Online Comment

Application H13-0876-25
Location SEAS END HALL HALL LANE MOULTON SEAS END PE12 6LB
Proposal Refurbishment of existing coach house and conversion into entertaining area including extension to include swimming pool

Name Ruben Lopez Catalan
Address Lincolnshire County Council, County Offices, Newland, Lincoln LN1 1YL
LN1 1YL

Existing Elevations Of  
Coach House

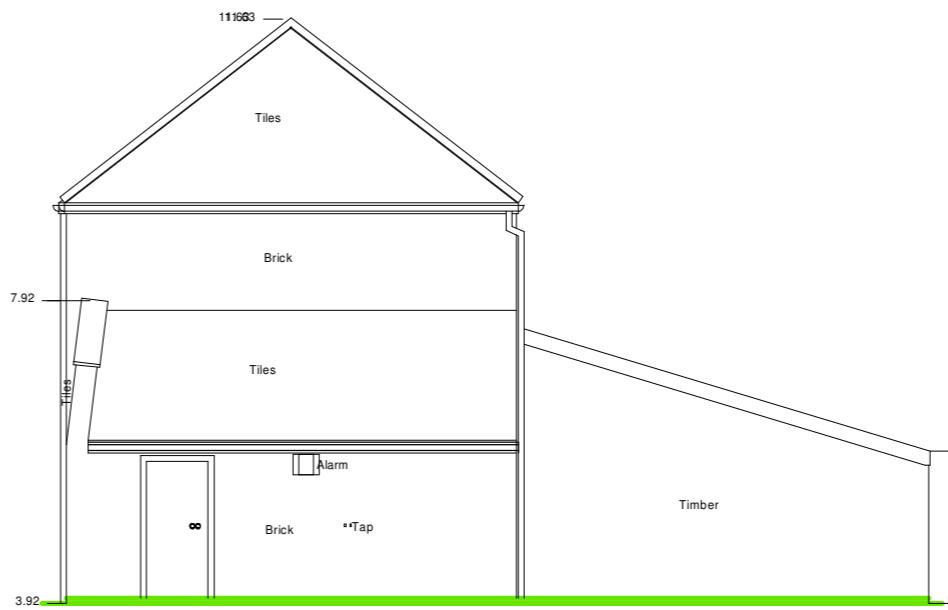
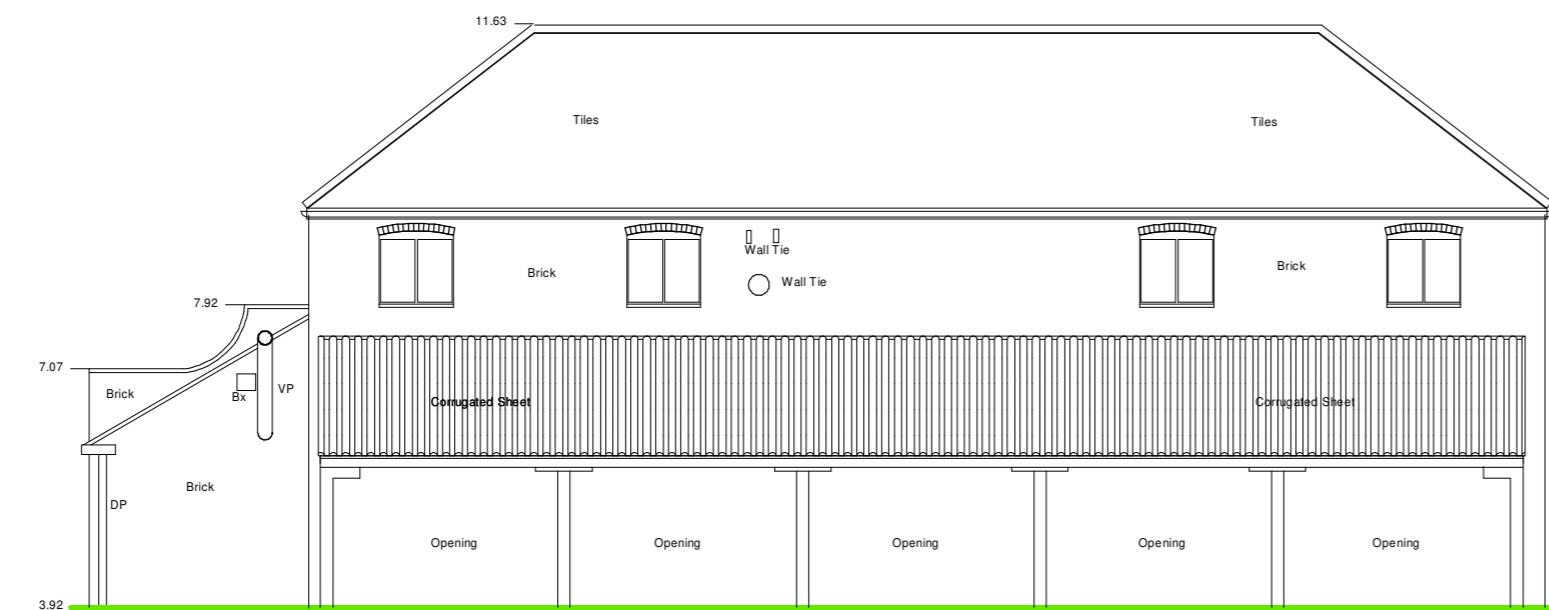
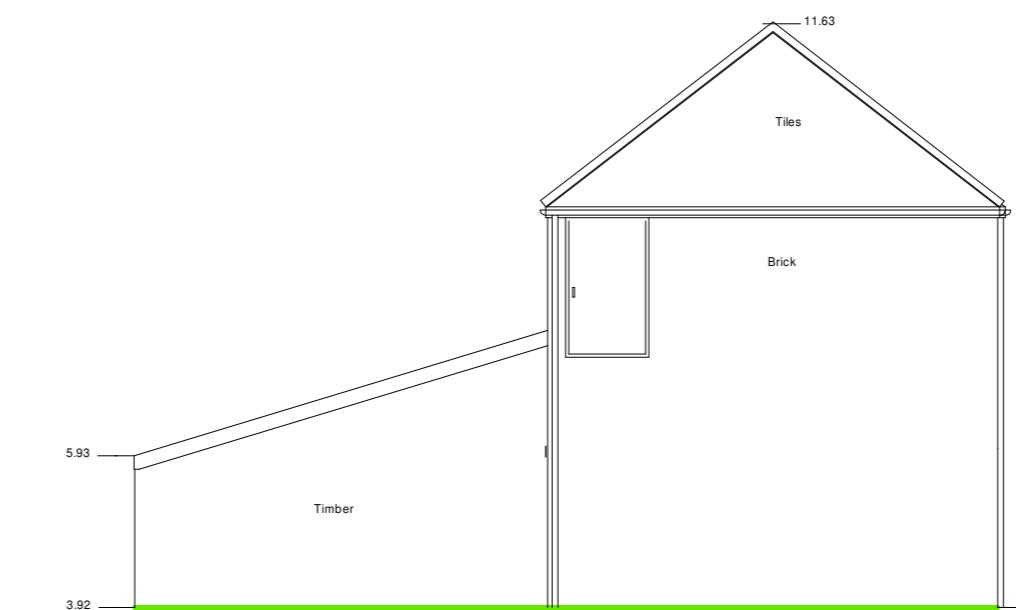
The Design and Access Statement accompanying the application identifies the dwelling as Seas End Hall (1064468), a Grade II Listed Building. The coach house is a non-designated heritage assets (NDHA), particularly in the context of a historic farmhouse within the curtilage that contributes to the evolution of the wider historic setting of Seas End Hall. According to Historic England's guidance, structures within the curtilage of a listed building are considered part of that listed building. Therefore, the coach house hold heritage significance due to their location within the curtilage of Seas End Hall. Their presence contributes to the understanding of the property's historical development and the broader historic environment.

Conversion will have a significant impact on any surviving original fabric of the building.

I recommend that if permission is granted, there be a condition for a mitigation strategy to effectively deal with this site.

This will comprise a phased programme of mitigation work including, but not limited to, a level 3 historic building recording of the coach house, in accordance with Historic England's document 'Understanding Historic Buildings: A Guide to Good Recording Practice. (2016).' This will enable the buildings to be recorded prior to conversion, alterations and refurbishment.
